City of Portland, Maine - Building or Use Permit Application
 389 Congress Street, 04101 Tel: (207) 874-8703, Fax: (207) 874-8716

Permit No: 04-1620	Issue Date: NOV 12 2004	CBL: 261 B063001
-----------------------	----------------------------	---------------------

Past Use: Single Family Home	Proposed Use: Single Family Home / Amendment to Permit#041267 Scaling back original plans	Permit Fee: \$66.00	Cost of Work: \$5,000.00	CEO District: 3
Proposed Project Description: Amendment to Permit#041267 Scaling back original plans		FIRE DEPT: <input type="checkbox"/> Approved <input checked="" type="checkbox"/> Denied <i>N/A</i>	INSPECTION: Use Group: R-3 Type: SB <i>IRC 2003</i>	
		Signature:	Signature:

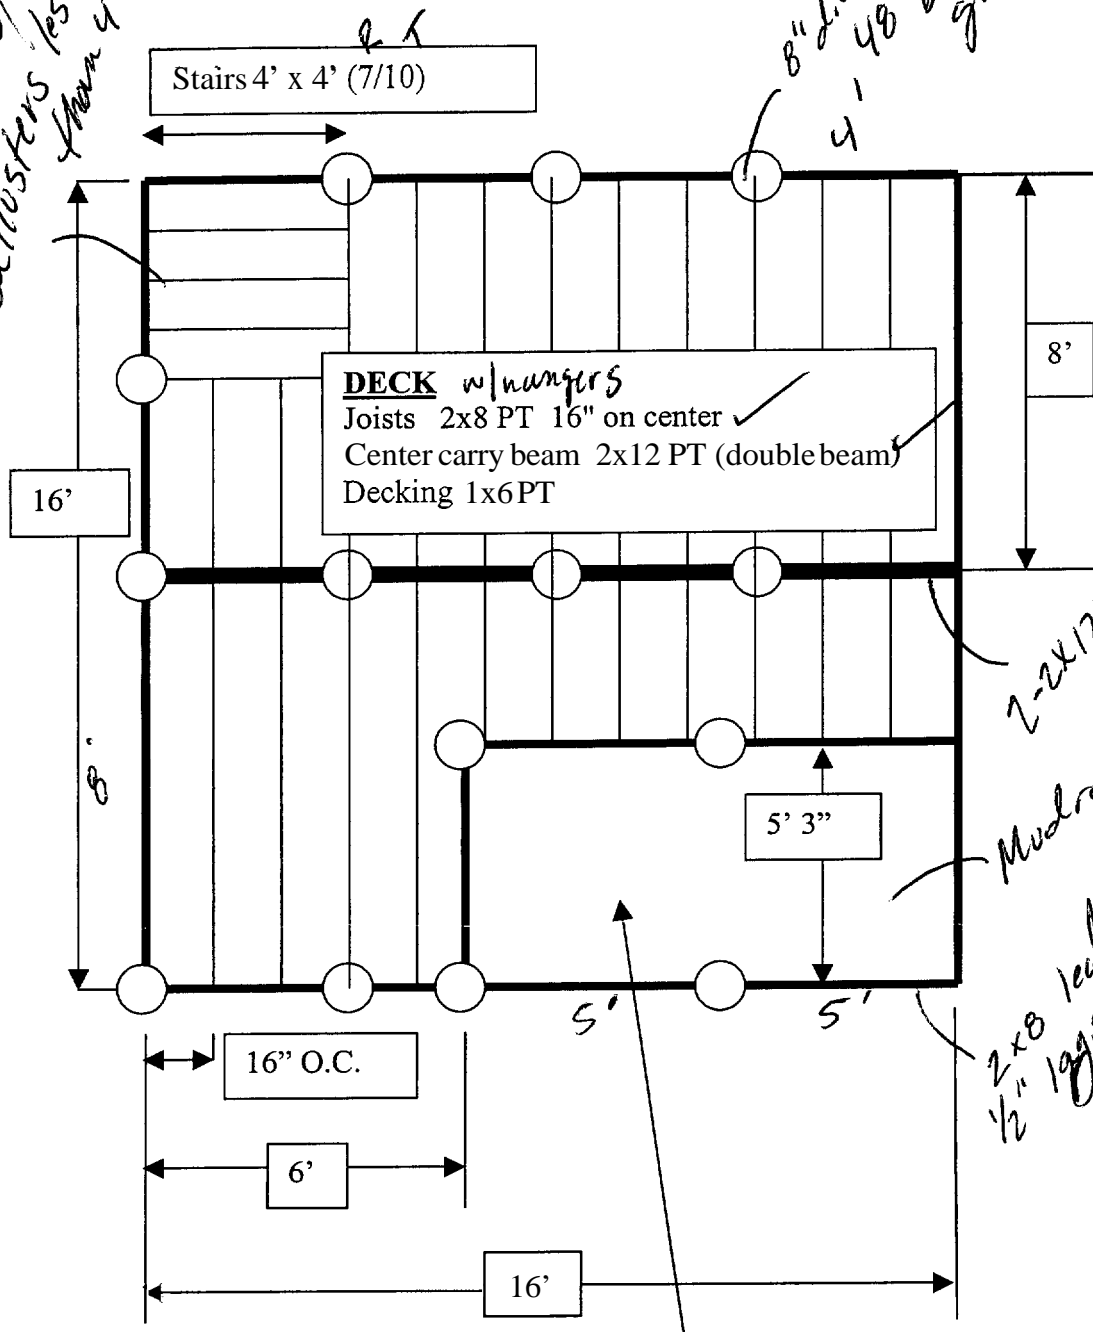
Dept: Zoning Status: Approved Reviewer: Tammy Munson Approval Date: 11/10/2004
 Note: ok under 14-433 for rear setback to be reduced. Ok to Issue:

- 1) All requirements under the previous permit are still applicable.
- 2) Permit approved based on the plans submitted and reviewed w/owner/contractor, with additional information as agreed on and as noted on plans.

- MUD ROOM CONSTRUCTION**
- Main Wall Construction - 2x6 16" on center ✓
 - Hurricane corner construction ✓
 - 2x10 window and door header construction ✓
 - Double 2x6 plate and sill construction ✓
 - Roof Construction - 2x8 16" on center 4/12 pitch ✓
 - 2x10 ridge post ✓
 - 1/2 exterior plywood on walls ✓
 - 3/4 exterior plywood on roof ✓
 - 3/4 T&G plywood on floor ✓
 - R19 insulation in exterior walls ✓
 - R38 in ceiling ✓
 - 36"x80" Insulated Door ✓
 - 36"x54" Dbl Sash Window ✓
